CITY OF ALBUQUERQUE

May 21, 2020

**RE: Sonta Trails Unit 4 Apartments
Conceptual Grading & Drainage Plan and Drainage Report
Engineer's Stamp Date: No Stamp Date
Hydrology File: C10D001A**

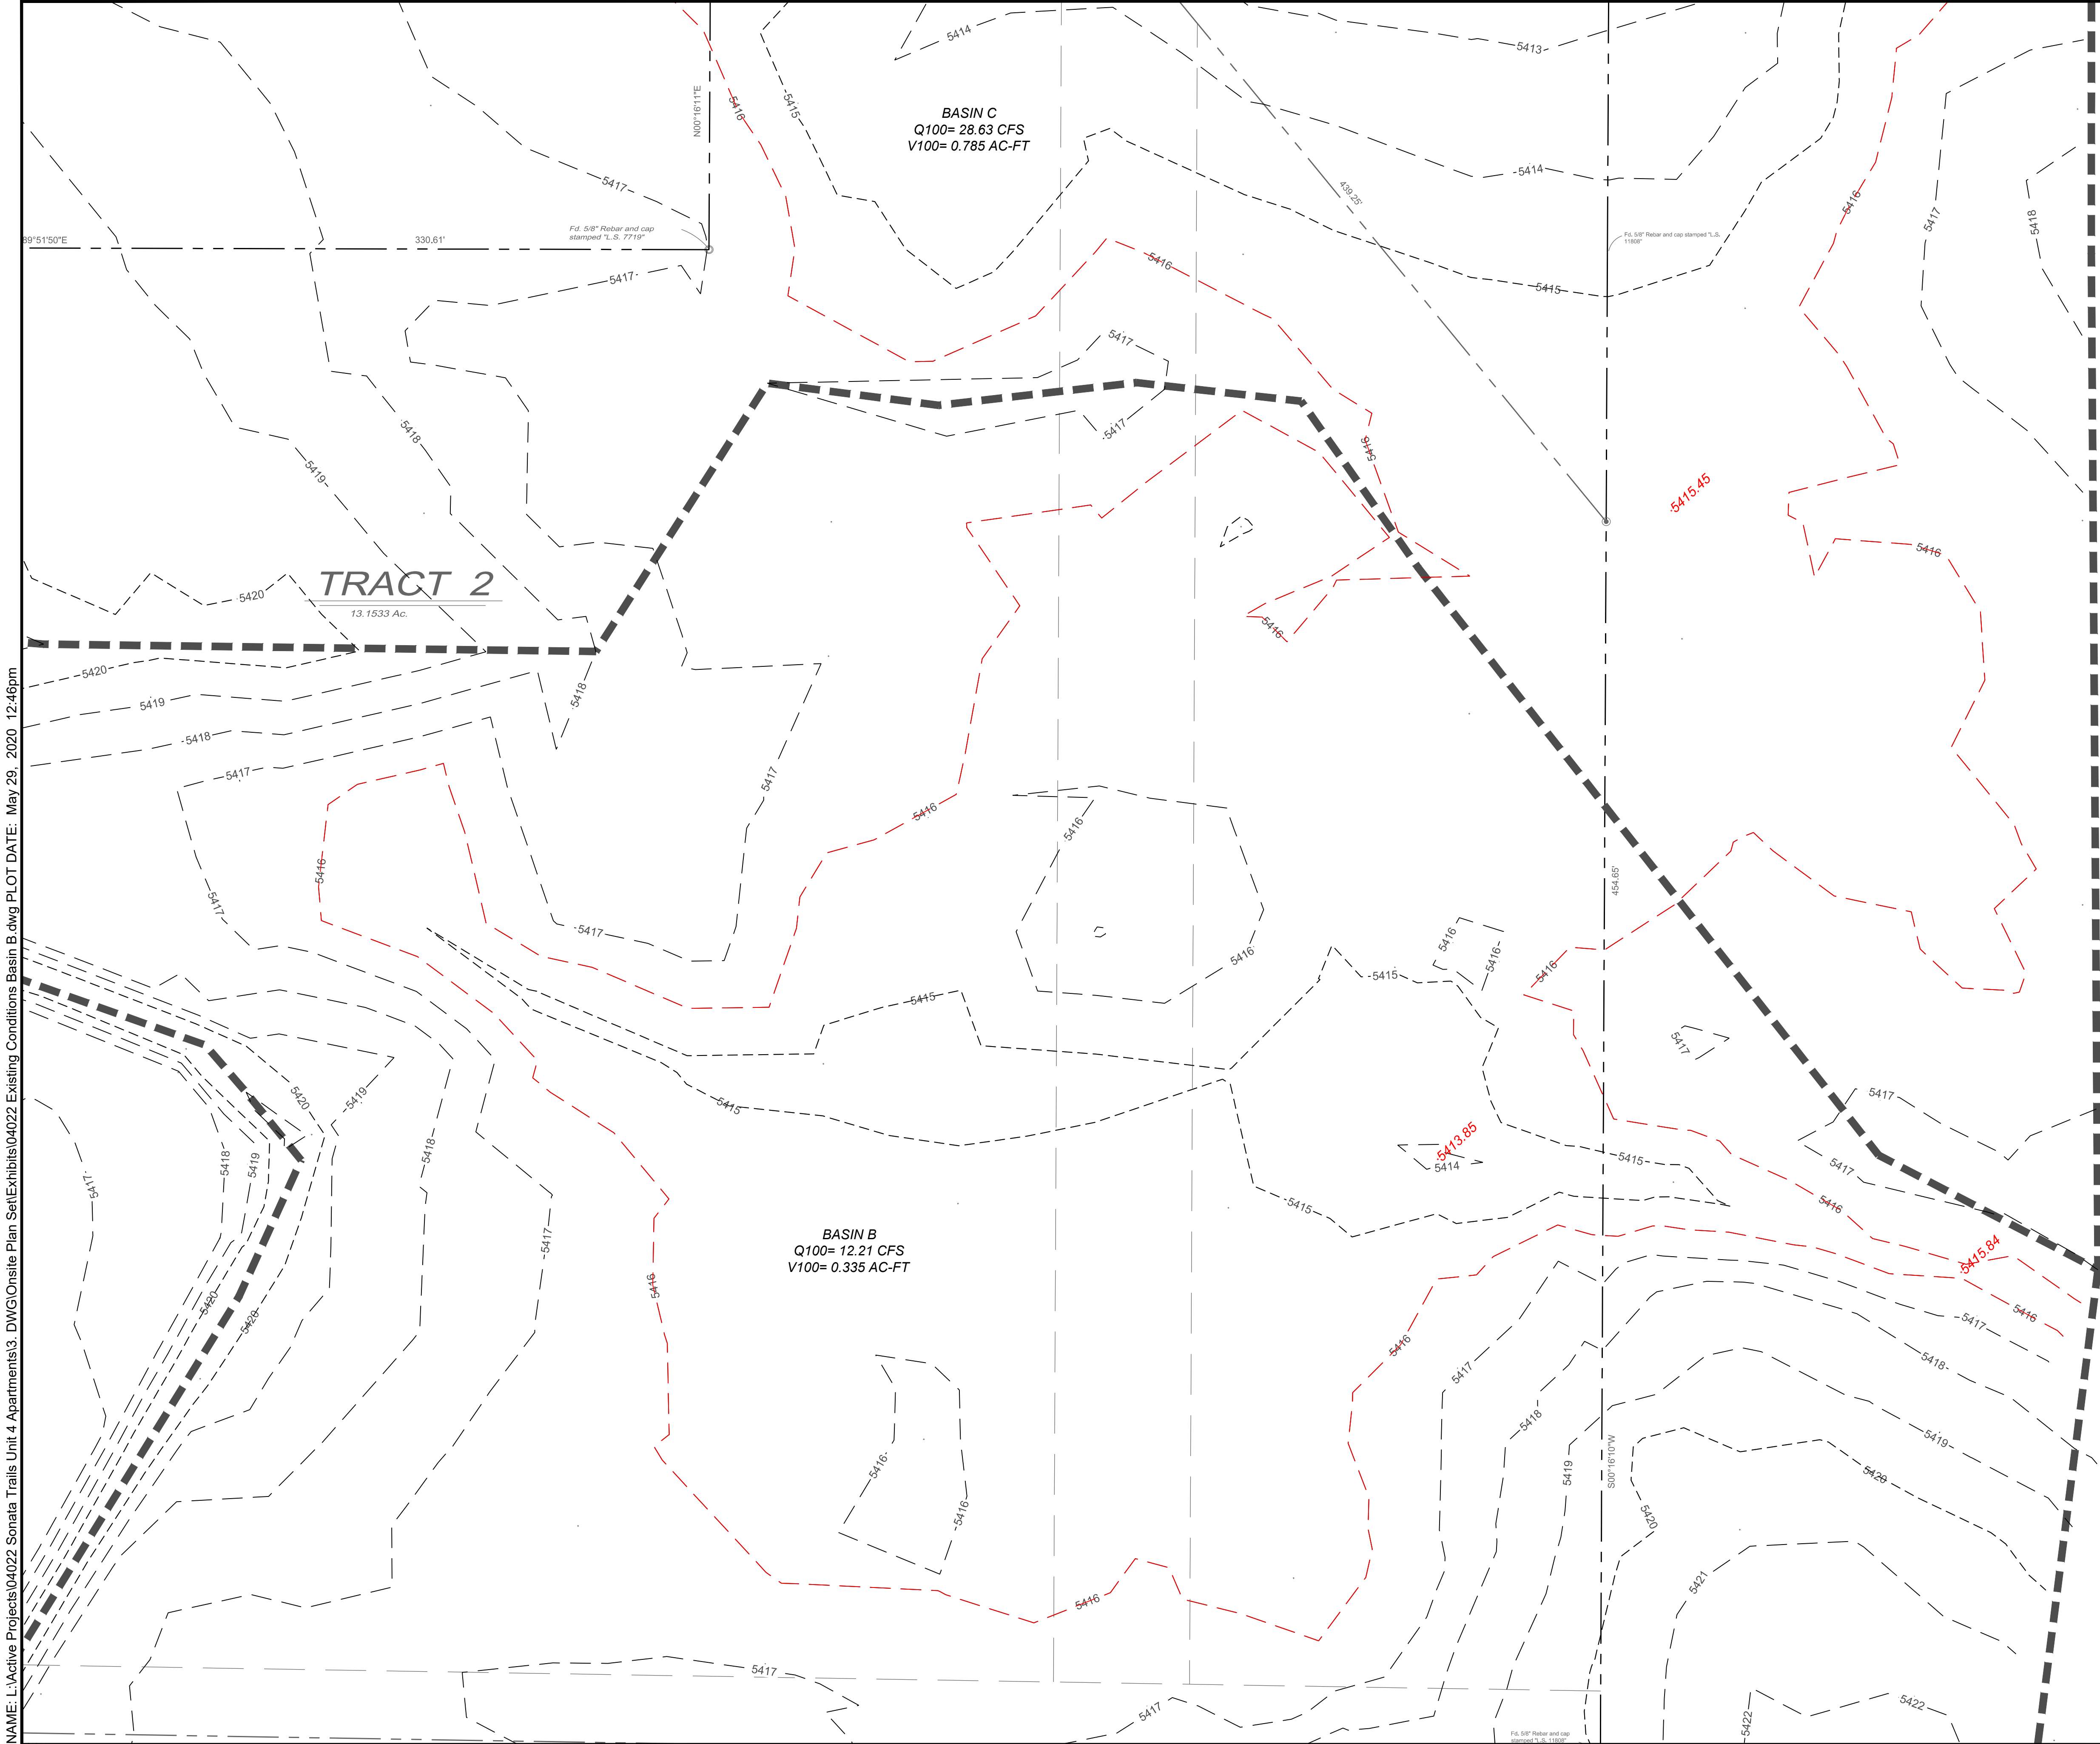
4. Please mention that the site also fall within "Upper Piedras Marcadas Watershed Drainage Management Plan by Wilson & Company dated April 2017.
5. Please also mention that the project ultimately drains into an Albuquerque Metropolitan Arroyo and Flood Control Authority (AMAFCA) facility (Piedras Marcadas Dam).
6. In reviewing Existing Basin B with provided existing contours and the City's LiDAR information, the existing Basin B does not drain to existing Basin C to the northeast but rather is drains to the southeast. Therefore the existing 12.21 cfs drains to the southeast, Please review and revised.

7. Since existing Basin B drains to the southeast, existing Basin C (28.63 cfs) and ½ of existing Basin A (3.44 cfs) drains to the northeast for a total of 32.07 cfs. Please review and revise.
